## KVFR Prevention Short Plat Comments

Project: Davenport Short Plat of TPN 556136

Permit#: SP-24-00007

Date: 05/23/2024

DAVENPORT SHORT PLAT
PART OF SECTION 32, T. 19 N., R. 19 E., W.M.
KITTITAS COUNTY, WASHINGTON

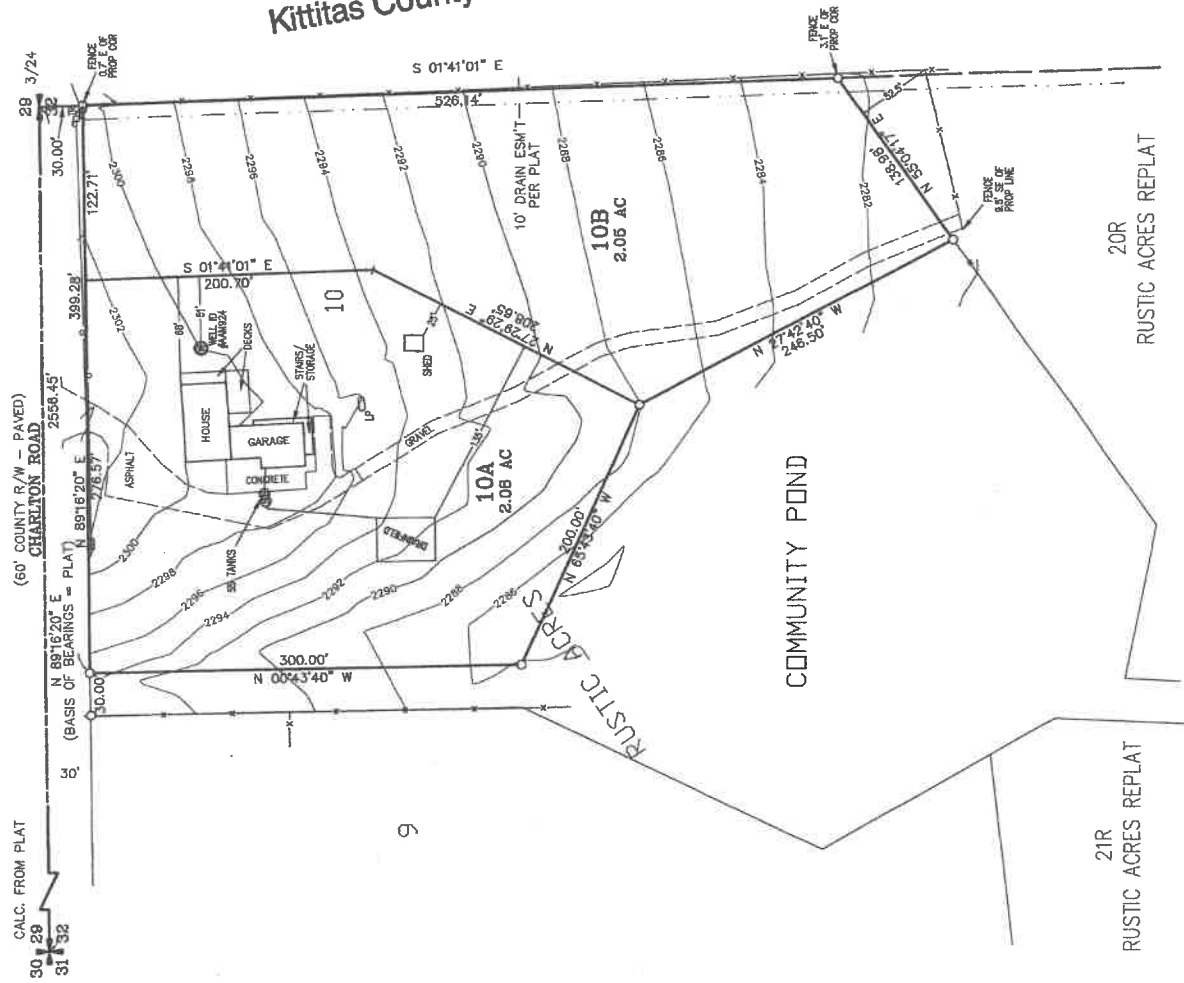
- Fire apparatus access roads exceeding 150' shall be provided with a temporary or permanent turnaround meeting the requirement 2021 IFC Appendix D.
- Fire apparatus access roads shall not exceed 10% in grade. This is especially critical in our valley's climate.
- The IFC Appendix D requires the road be a minimum of 20' wide and capable of supporting an imposed load of at least 75,000 lbs.
- Road turning radius required under IFC Appendix D are a minimum of 23' inside and 45' outside.
- Any future construction on the parcels shall be required to meet all water fire flow requirements as adopted by Kittitas County under WUI code and International Fire code.
